Discharge of details reserved by conditions 3 (Construction (Environmental) Management Plan), 6 (Temporary surface water management details), 8 (Proposed internal adoptable roads), 9 (Permanent site entrance details), 16 (Surface water attenuation details), 17 (Details of Swale/ditch management), 19 (Phase II Site Investigation details), 20 (Remediation Strategy), 25 (Noise Impact Assessment), 30 (Arboricultural Method Statement/ Tree Protection Plan), 34 (Biodiversity Gain Plan) of permission 2024/91260 for Variation of conditions 2 (plans and specifications) and 35 (removal of permitted development rights) of previous permission 2021/92801 for erection of 291 dwellings with associated works and access from Hunsworth Lane and Kilroyd Drive – revisions to house types, unit size mix and layout

Land at Merchant Fields Farm, off Hunsworth Lane, Cleckheaton

Application Number: 2025/90708

Earthworks - Surface Water Management

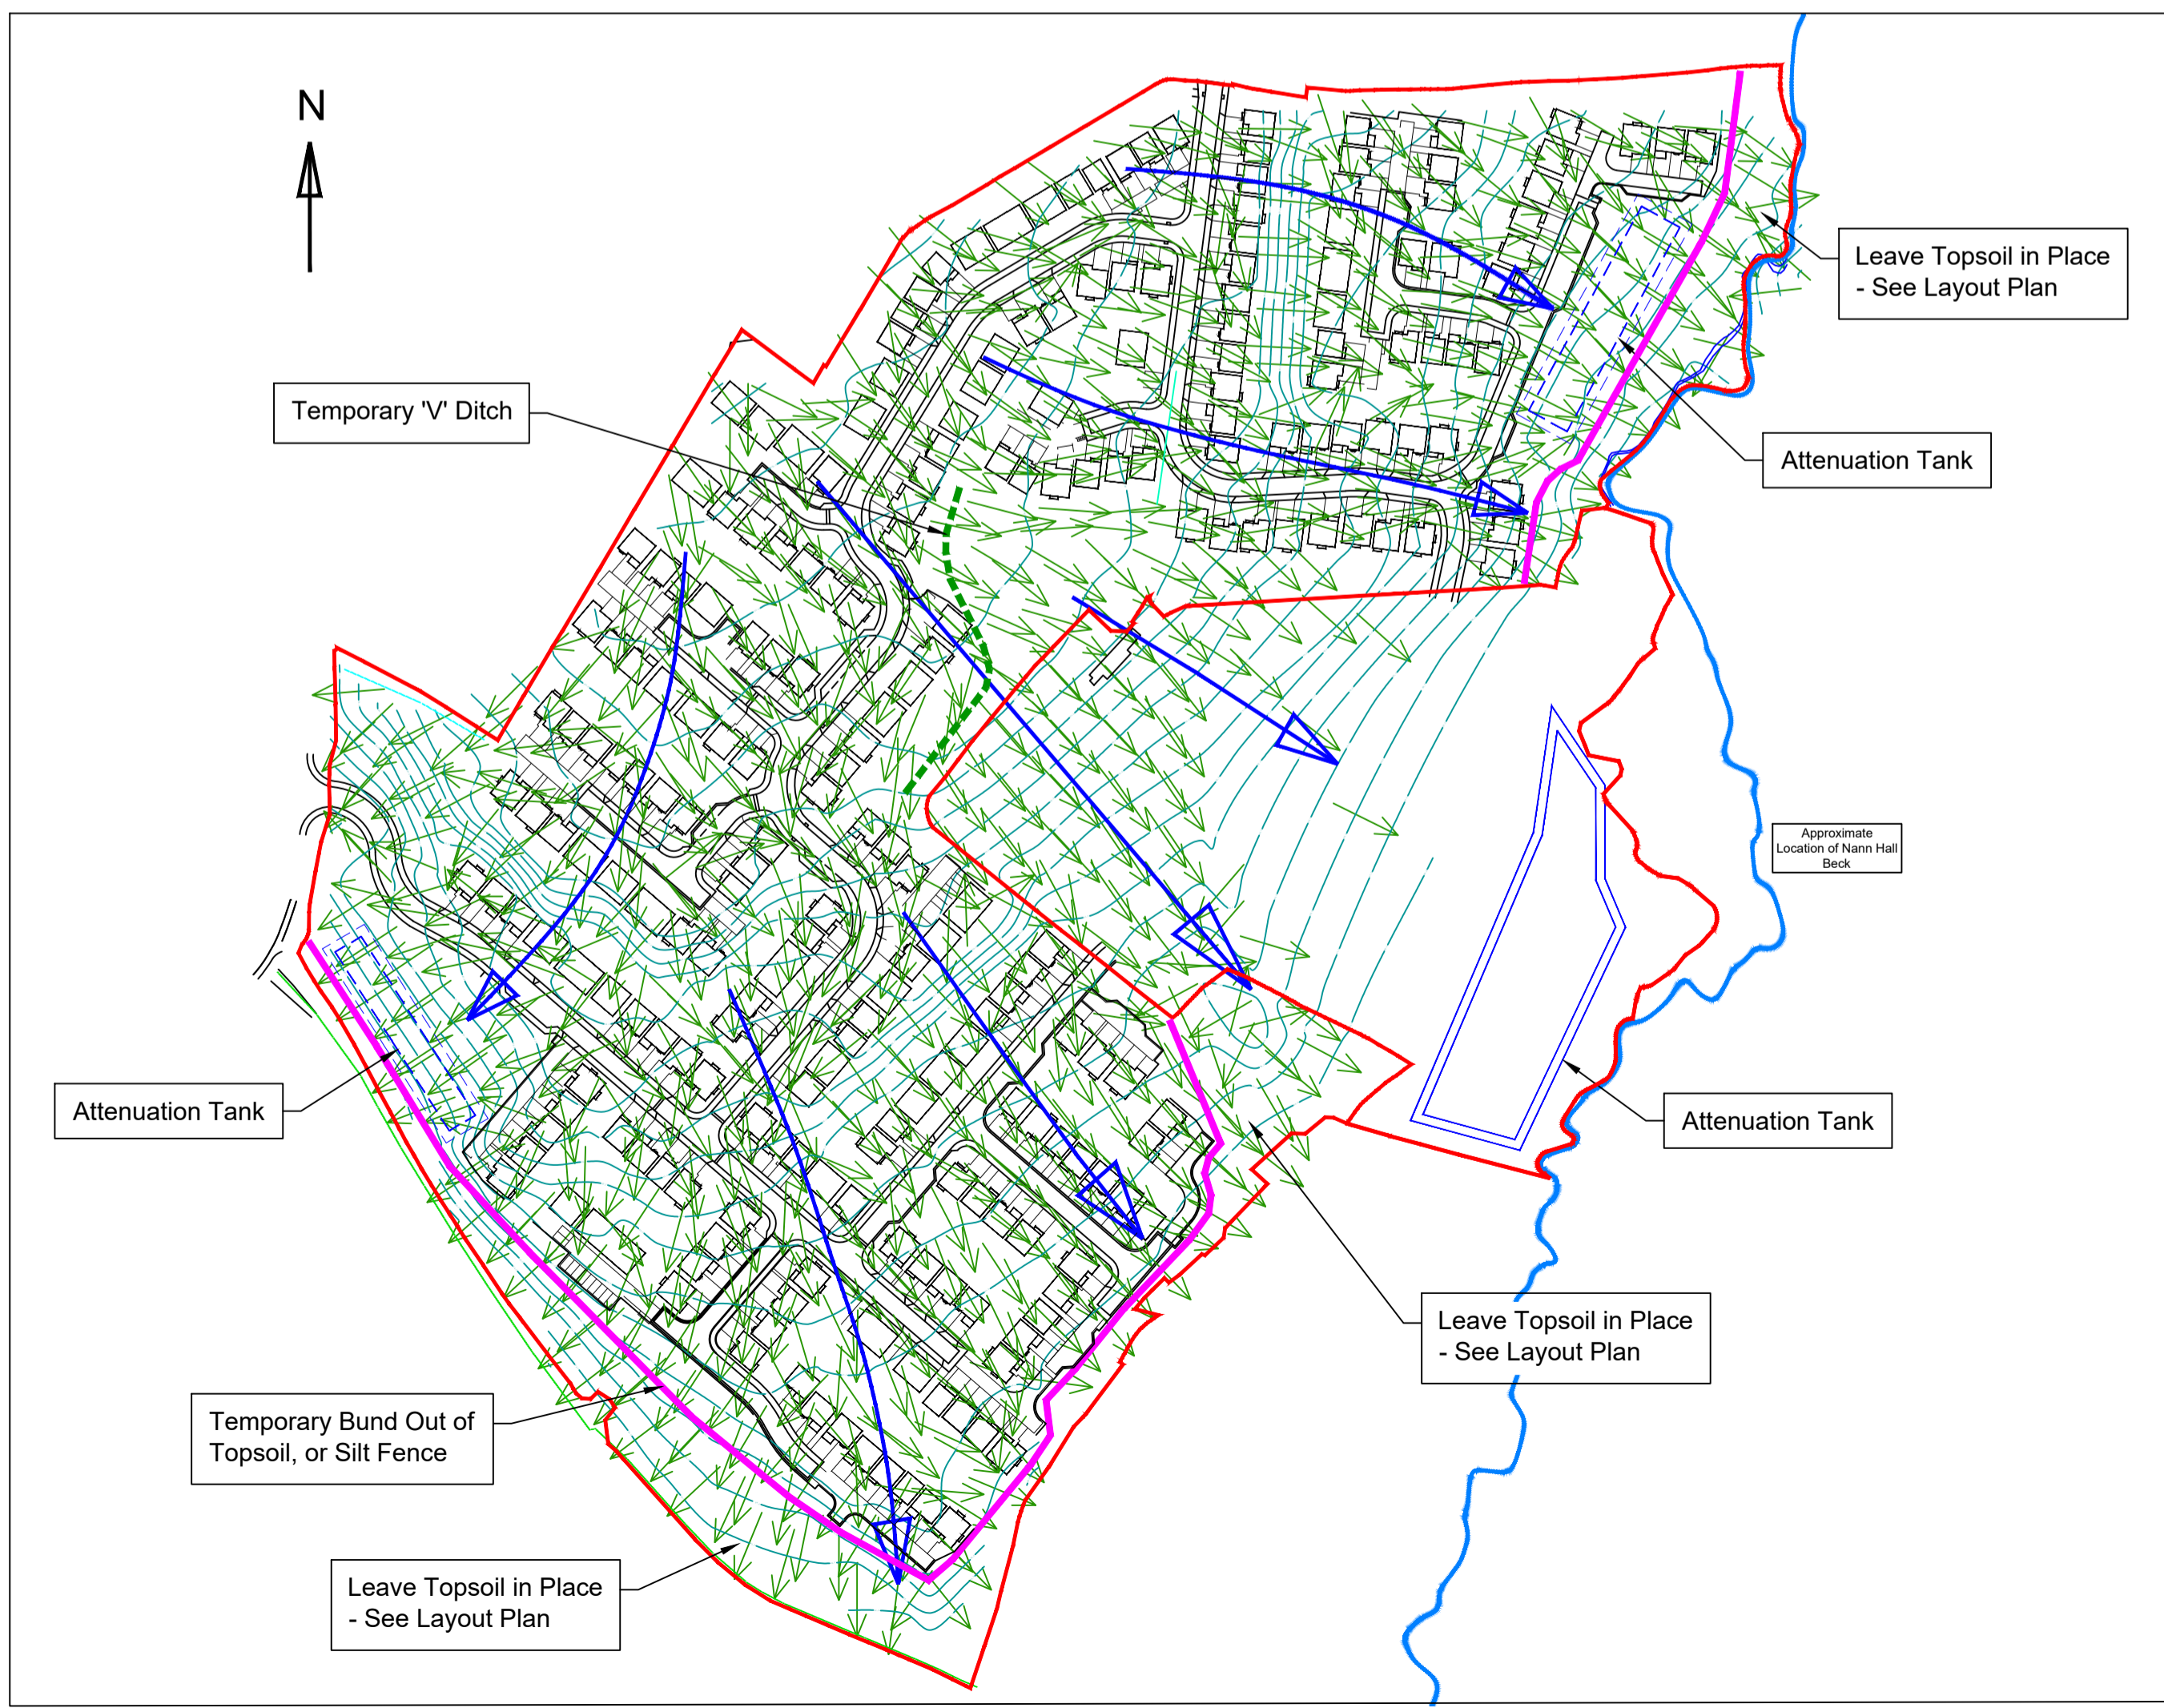
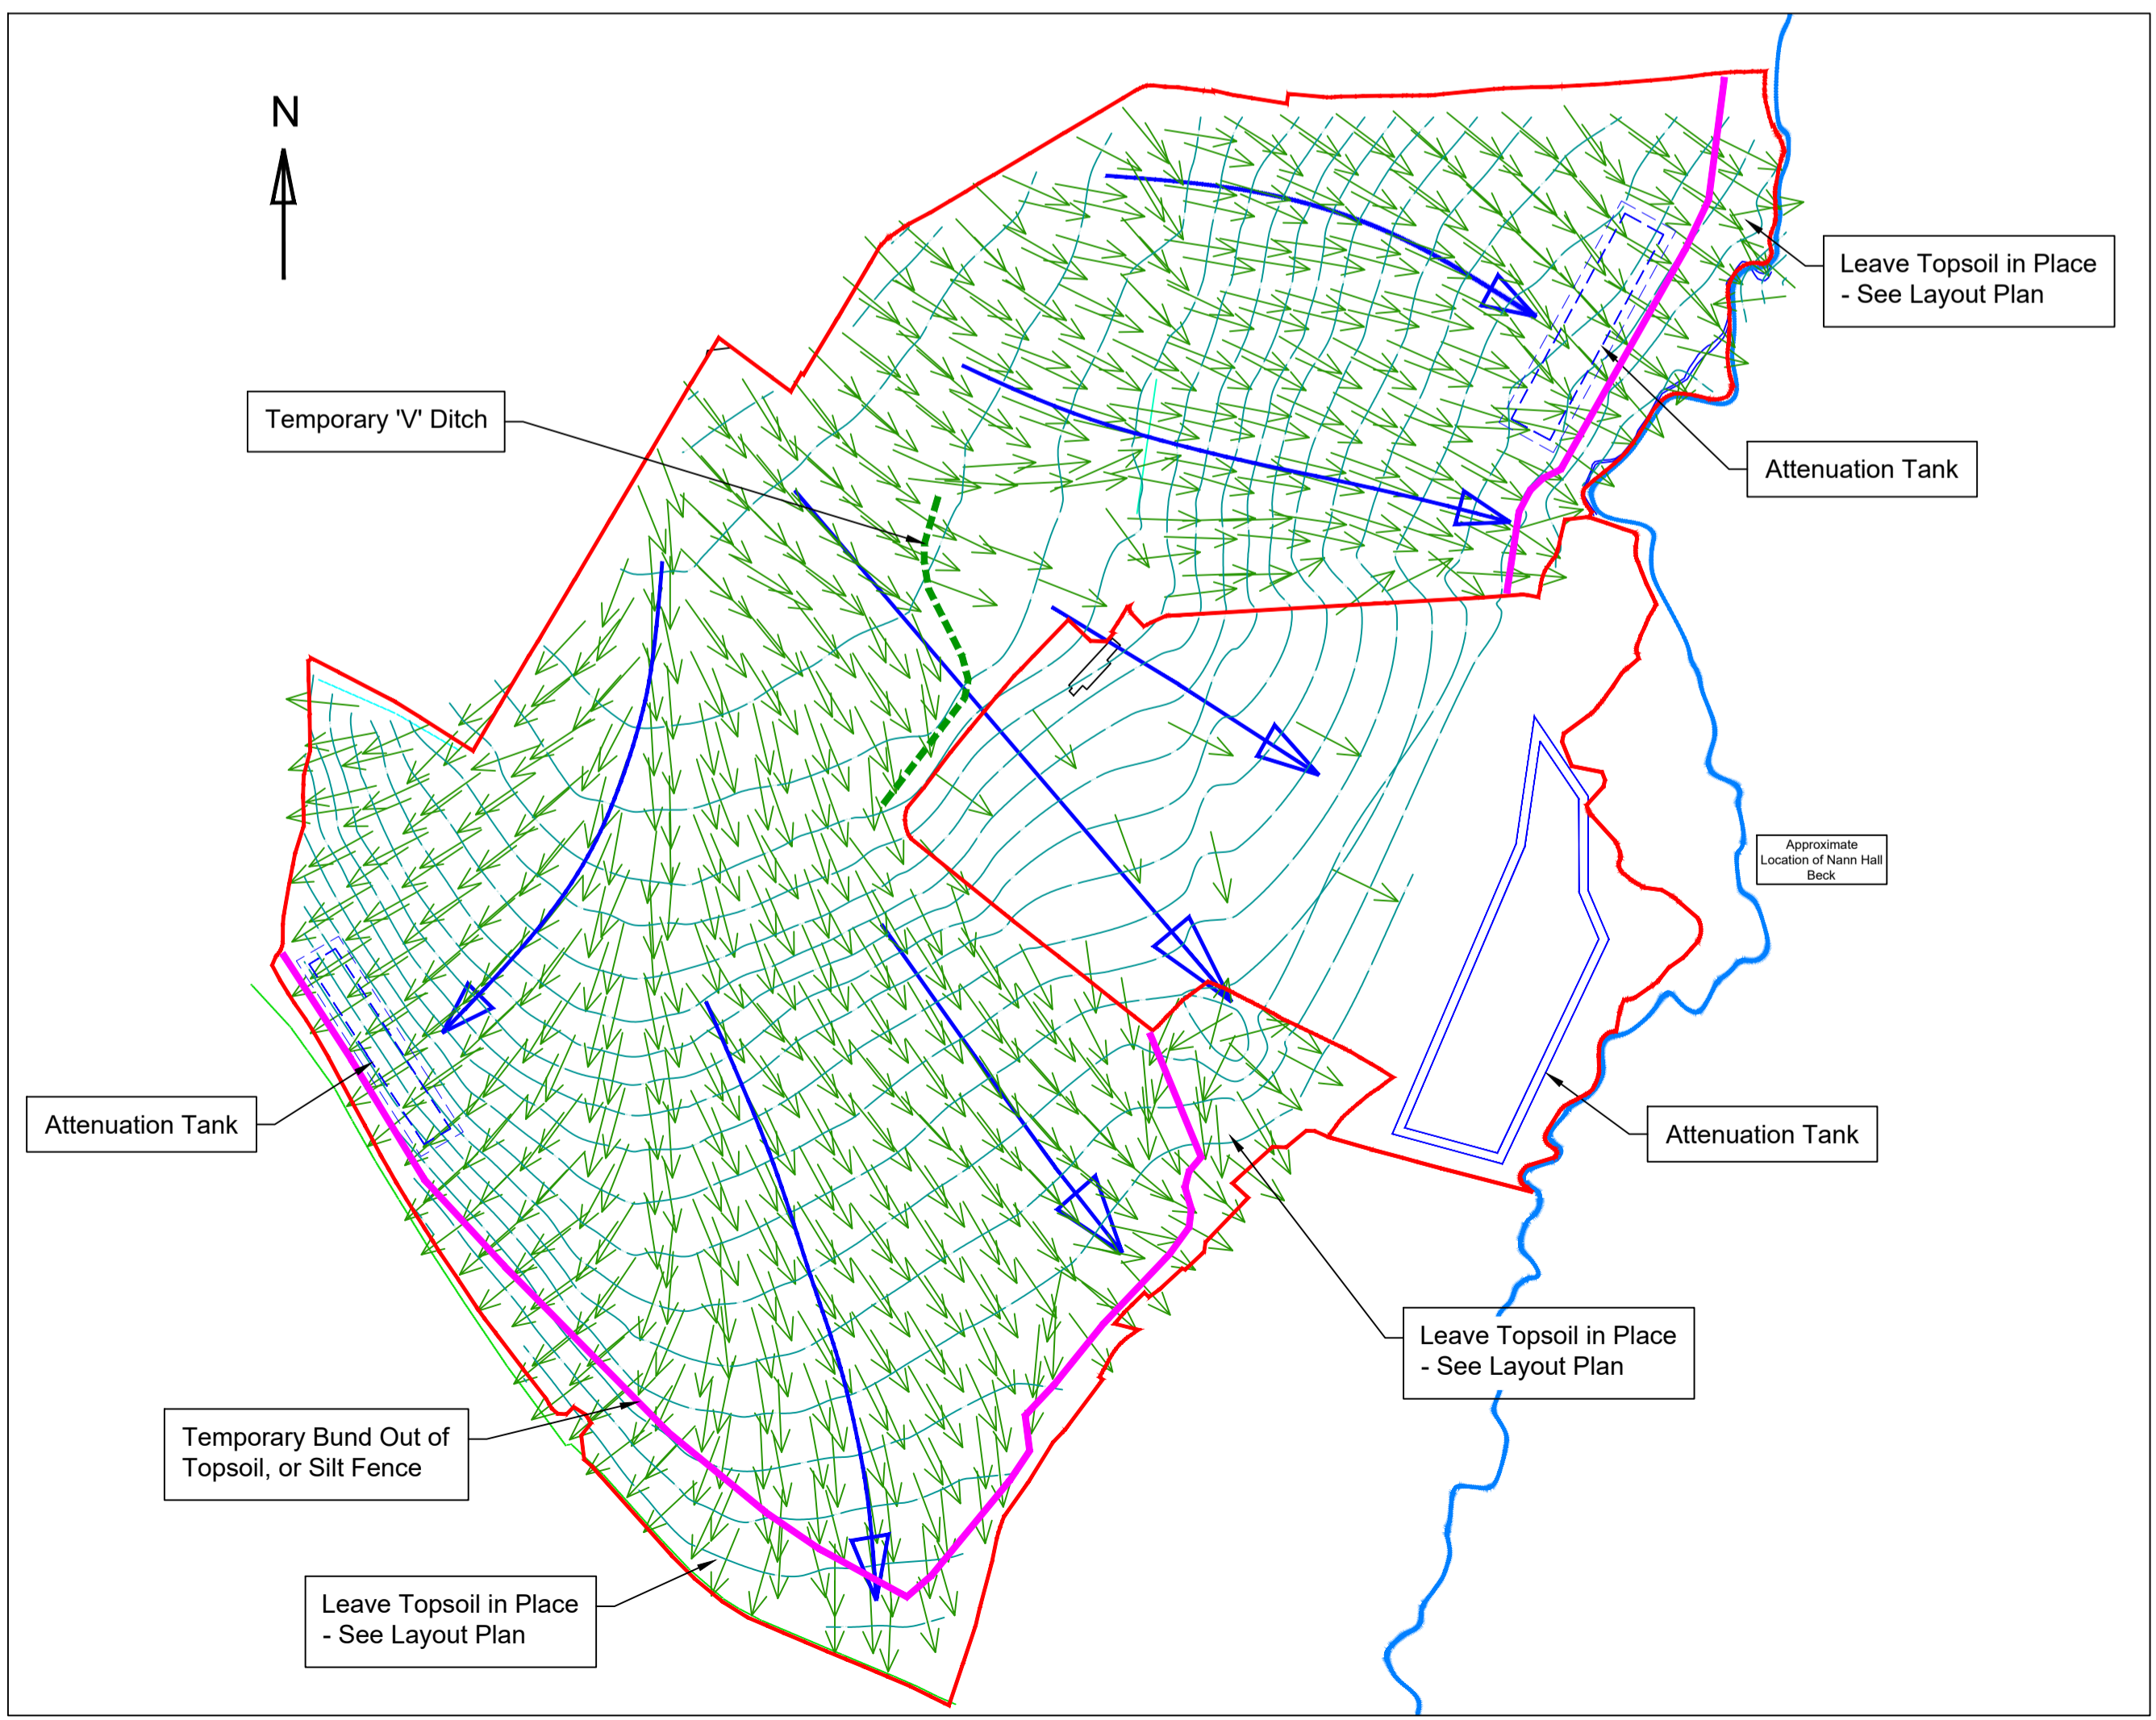
Condition 6 (temporary surface water management details) – You have submitted a Surface Water Management Plan (drawing D1874_23) pursuant to condition 6. Details set out in this drawing do not adequately address the requirements of condition 6. Please see the comments of the Lead Local Flood Authority dated 23/04/2025 for further advice regarding your submission's deficiencies.

You are invited to submit further details pursuant to condition 6 within two weeks of the date of this letter. If no further details are submitted within that timeframe, a new Discharge of Conditions application would need to be submitted.
